## DEVELOPMENT REVIEW BOARD SUPPLEMENTAL SUBMITTAL

PROJECT NO. PR-2018-1580 (1005234)  
Application No. SI-2018-00153

**SUBMITTAL DESCRIPTION:** DRB resubmittal - Use Change from Hotel to Apartment

**HOTEL WYNDAM CHANGES - CHANGE OF USE**

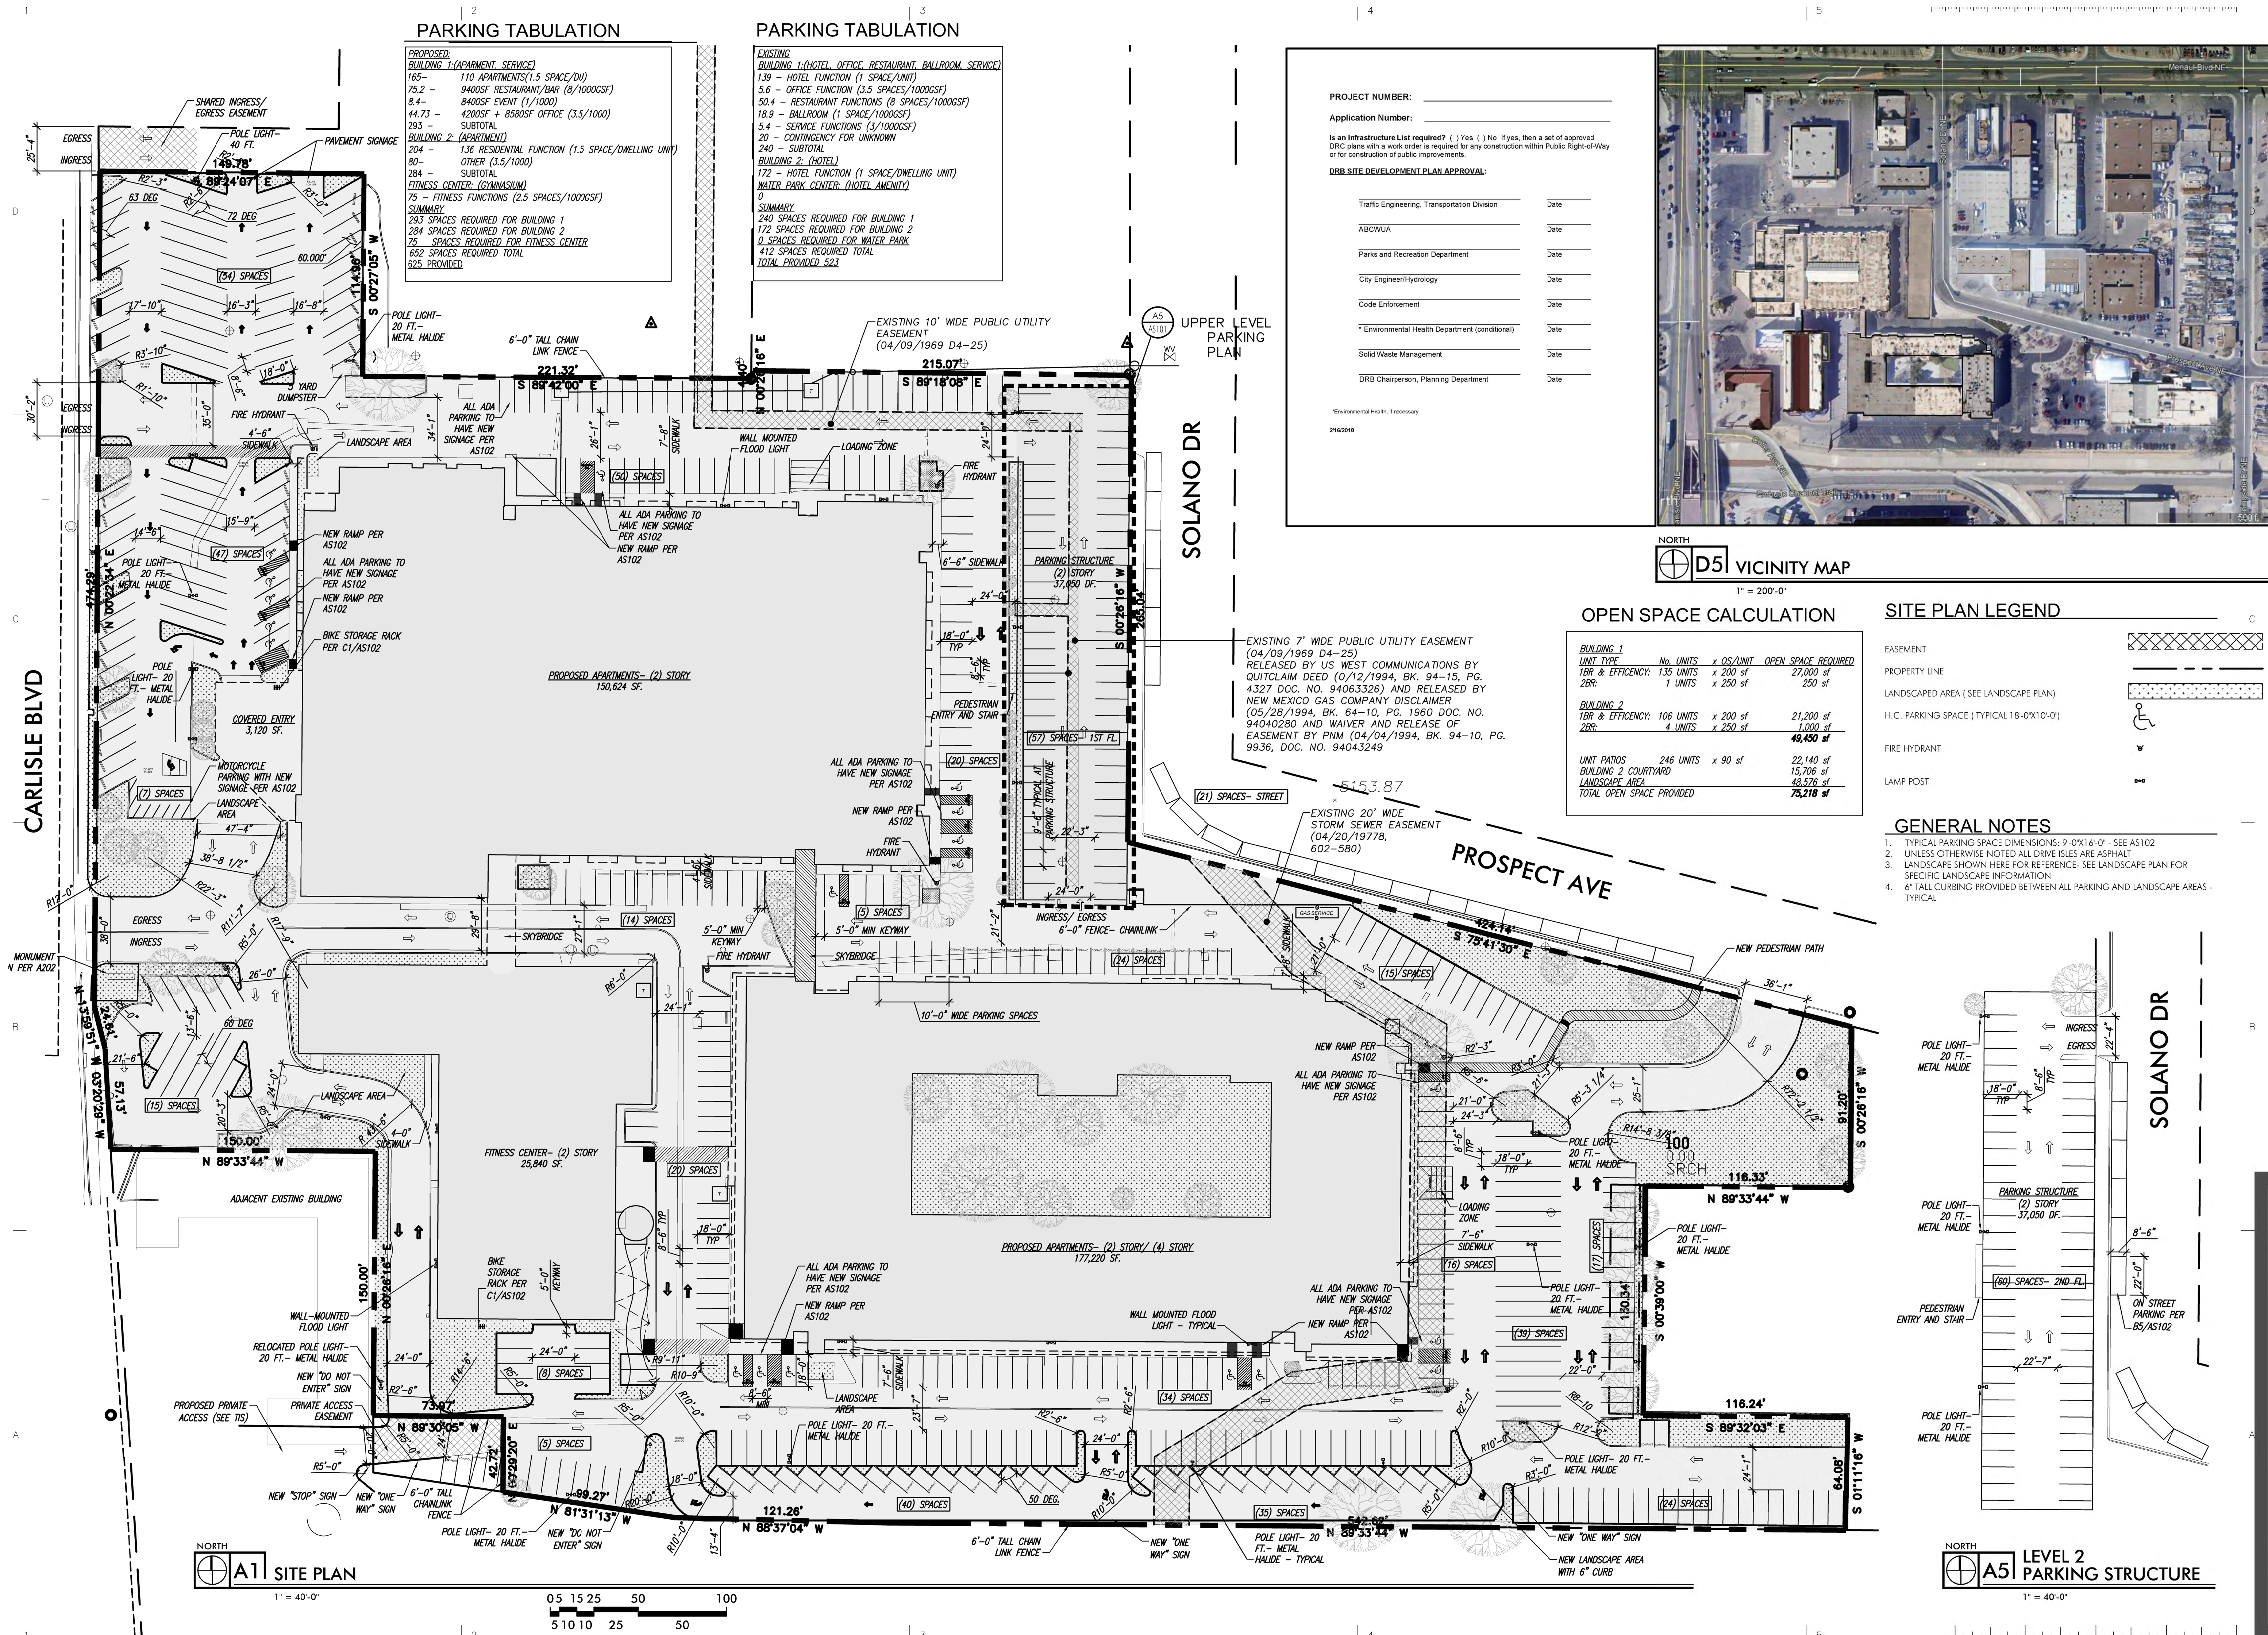
1. *Parking calculation is missing for ADA, and motor cycle parking.*
  - a. **ADA and motorcycle parking calculations have been added to the drawings. Please note the revised Parking Tabulations on AS101.**

6. *Parking spaces near the sky bridge may need to be compact. Provide the aisle width to the east of the bridge.*
  - a. **Parking spaces in this area have been revised to compact. Aisle dimensions have been added.**

7. *Parking spaces cannot be split by lot lines.*
  - a. **Noted. Where this occurs, we have eliminated a parking space. Once the lots are combined (under future action) we will replace the space.**

B3 | PARALLEL PARKING DETAILS

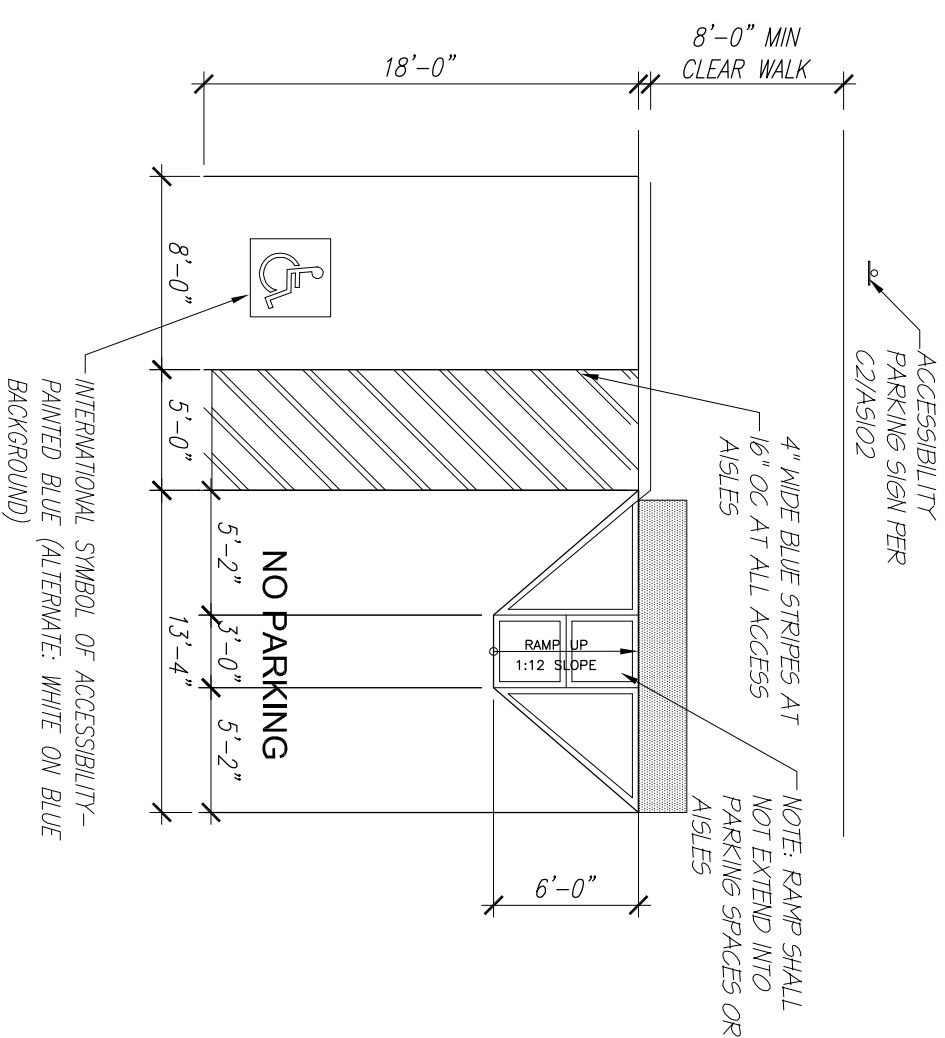
- a. **Locations have been updated and called out. Sign detail added to AS102.**
5. *Provide details for the rectangular spaces in Prospect Ave. Parking spaces are not laid out correctly.*

- a. **Revised parking calculations do not require use of On-Street Parking. All On-street Parking spaces along Prospect Ave. have been removed from the**

**Site Plan.**

18007
A202

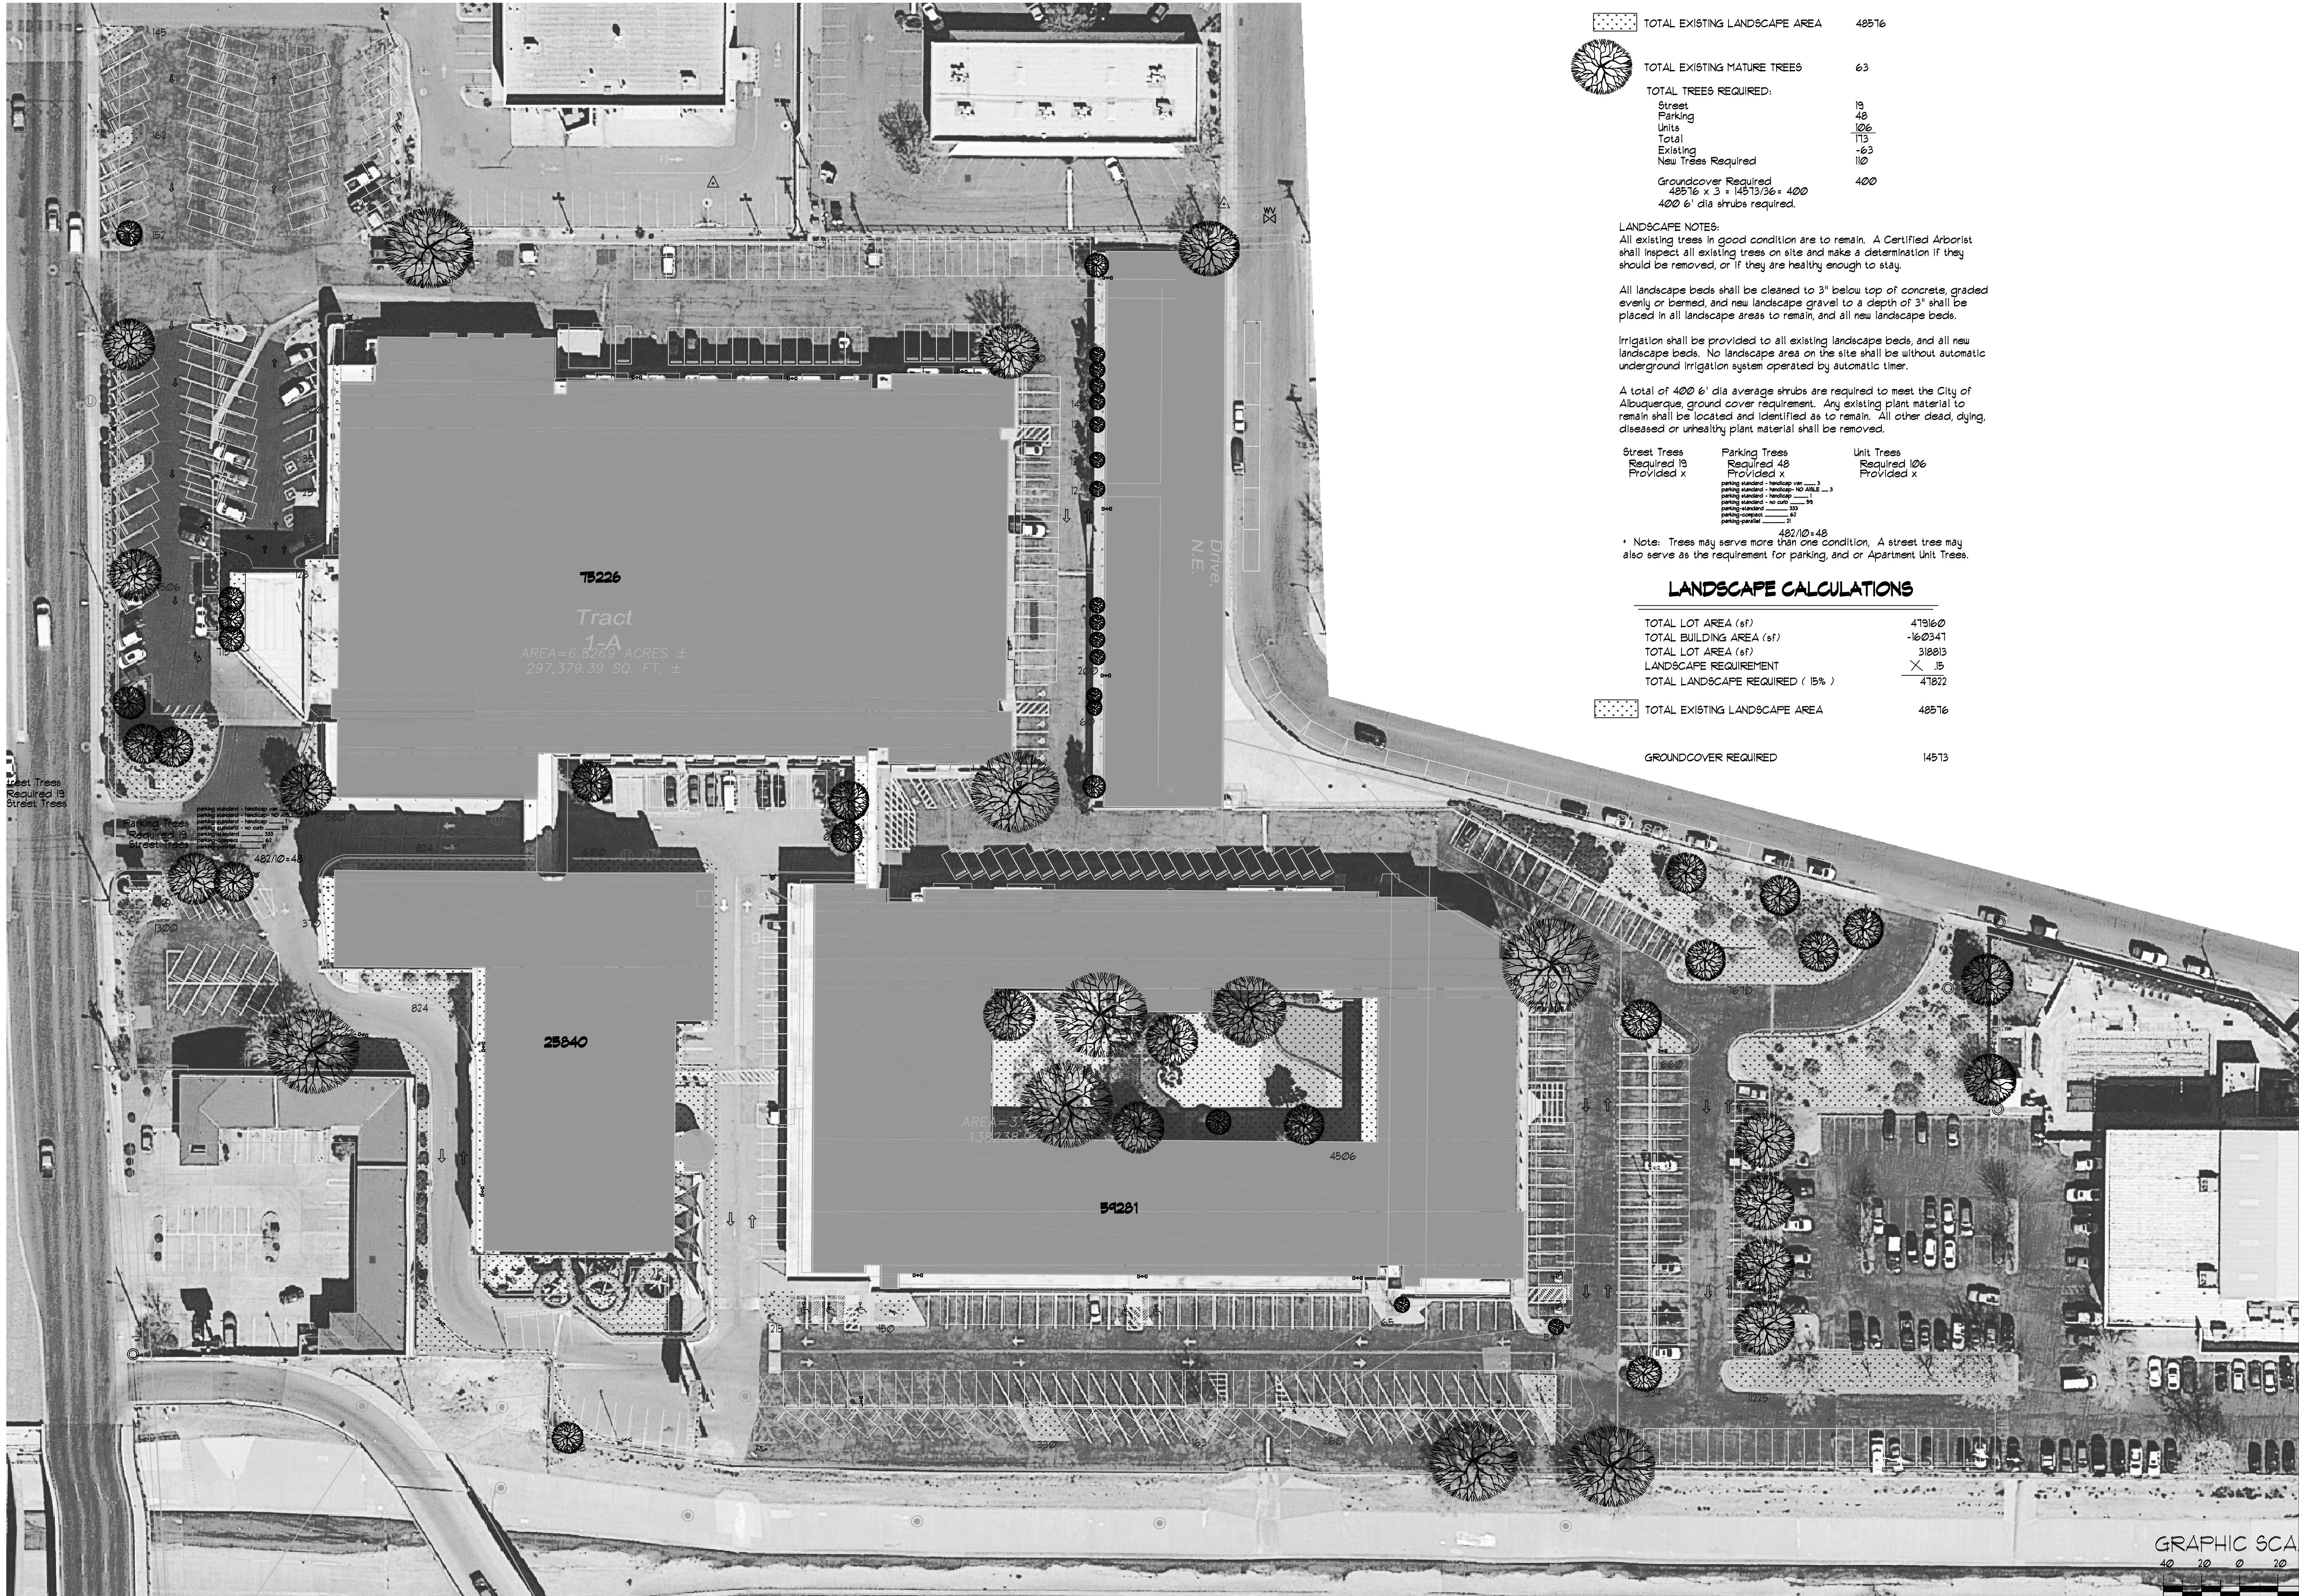
15. *Please add a note on building elevation sheets noting additional signage may be approved through the sign permit process if found to be in conformance with IDO Section 14-16-5-12. Did not see such a note on elevation sheet.*

**a. The requested annotation has been added to the sheet A202.**
